**Our Case Number:** ABP-314485-22

**Re:** A proposed development comprising the taking of a 'relevant action' only within the meaning of Section 34C of the Planning and Development Act 2000, as amended, which relates to the night-time use of the runway system at Dublin Airport.  
Dublin Airport, Co. Dublin

The Board received additional information from the Dublin Airport Authority (Daa) on the 14th of September 2023. This additional information includes noise contour maps which amend the terms of the Third Condition of the Regulatory Decision in relation to Figure 3.1 - Residential Sound Insulation Grant Scheme (RSIGS) and the "Initial Eligibility Contour Areas".

**Maps at a relevant scale, which will allow the Board to undertake an assessment of any comparison with Eligibility Contour Area maps in Fig 3.1 and Maps 1-23 of the Regulatory Decision, and the noise contours now proposed.**

Figure 3.1 – Regulatory Decision, Third Condition.
Residential Sound Insulation Grant Scheme (RSIGS) - Initial Eligibility Contour Area - June 2022

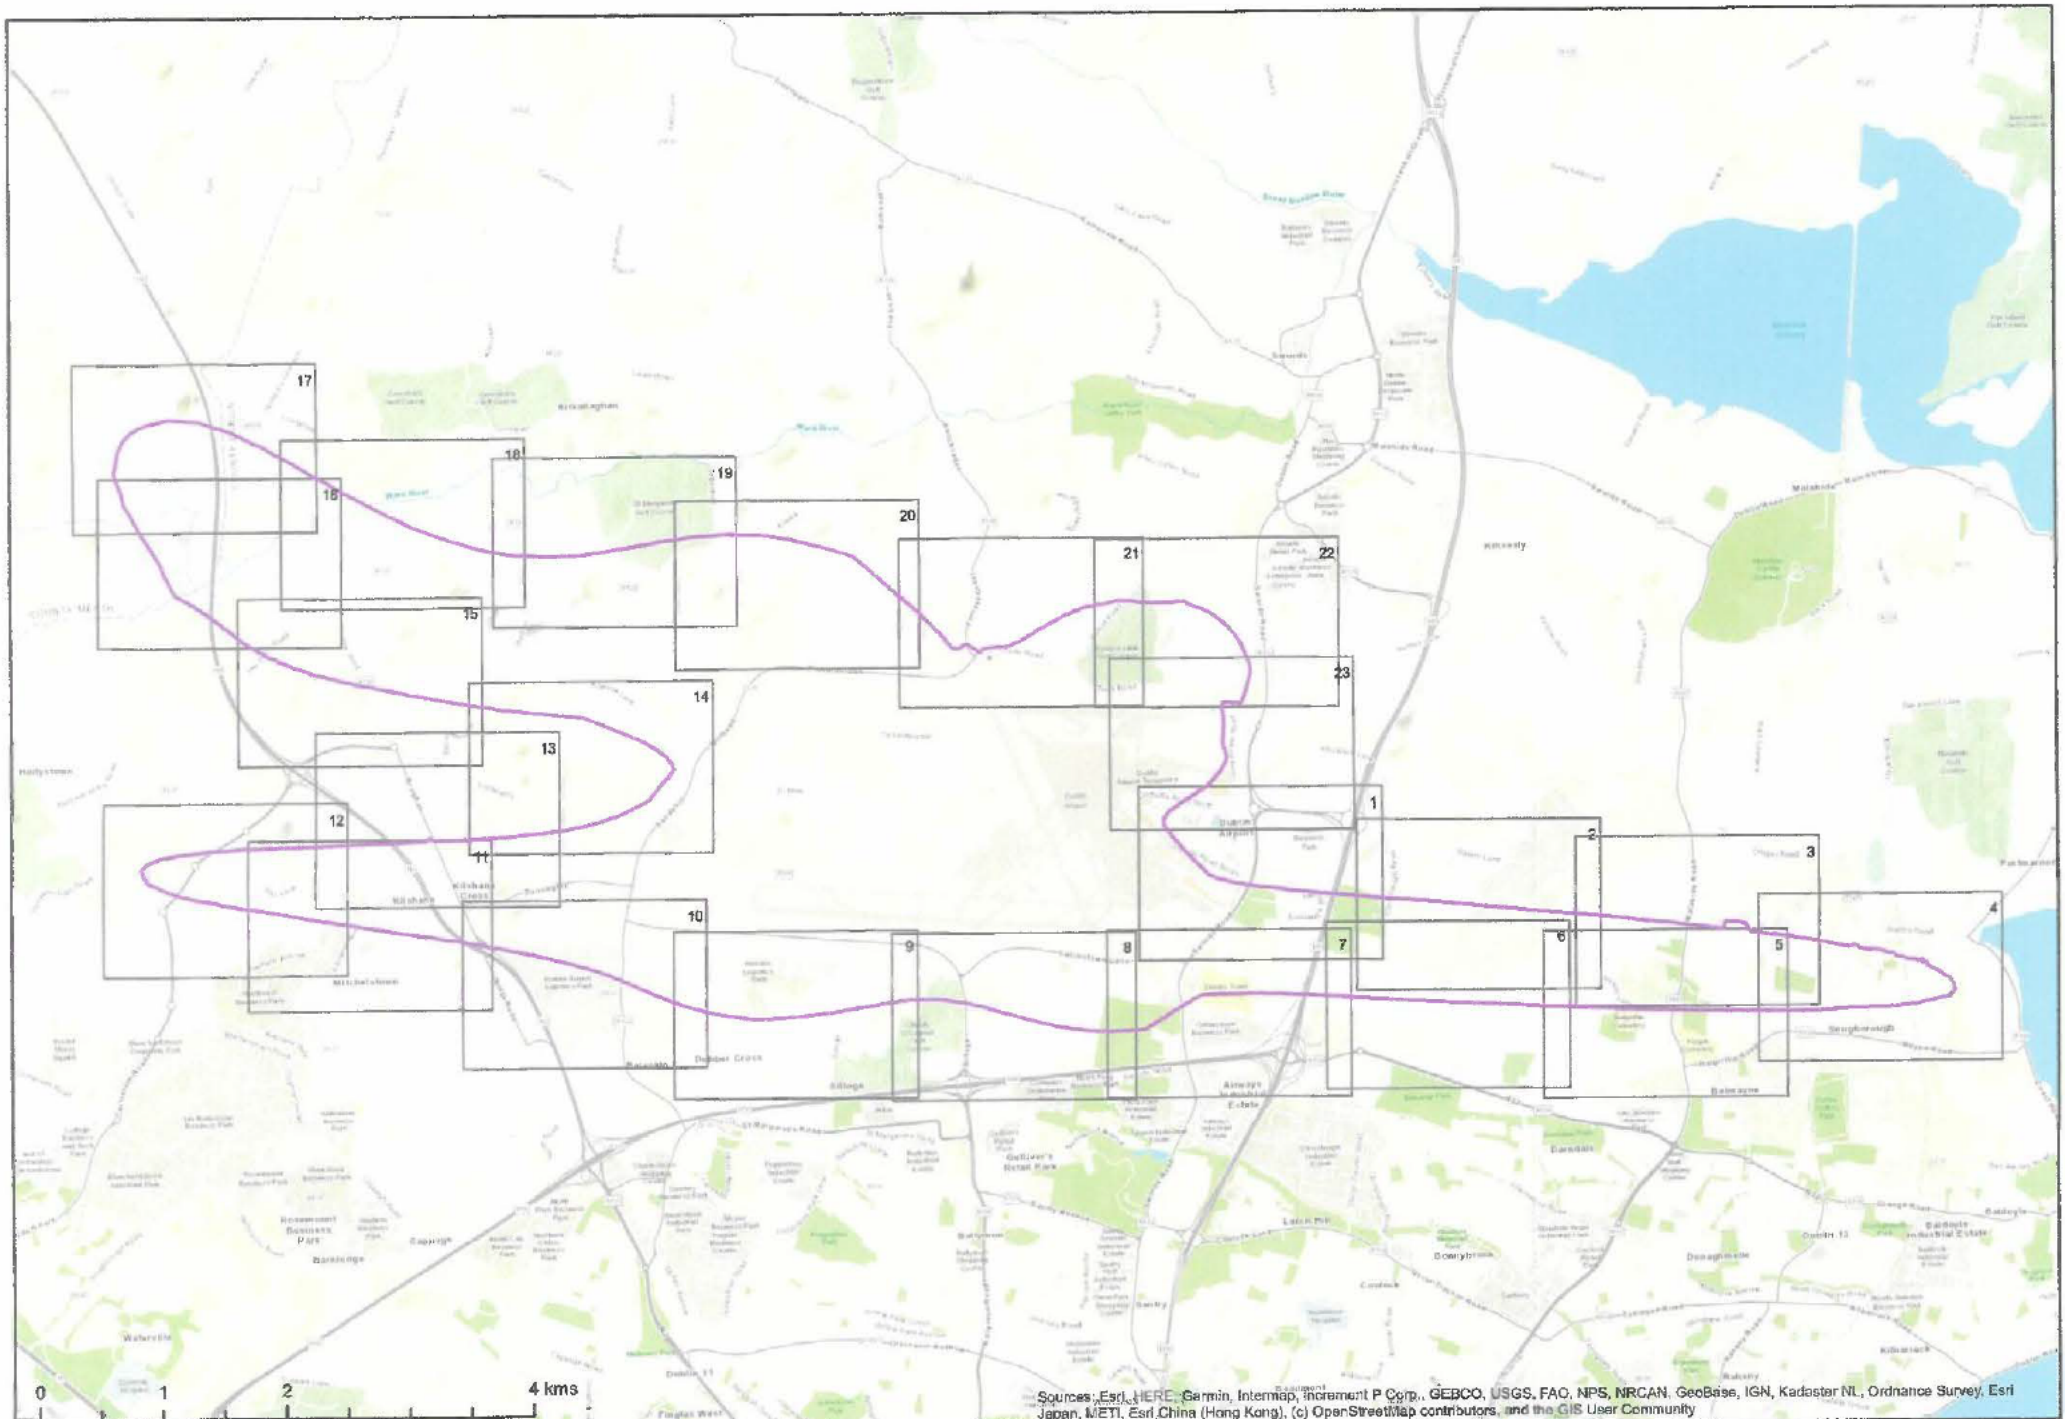
**Maps shall be provided at a scale of 1: 50,000 for Fig 3.1, and 1: 10,000 for Maps 1-23, or a scale otherwise agreed with the Board. The revised maps shall clearly illustrate all authorised habitable dwellings within the 55 dB Lnight and 63 Lden contour for the year 2025.**
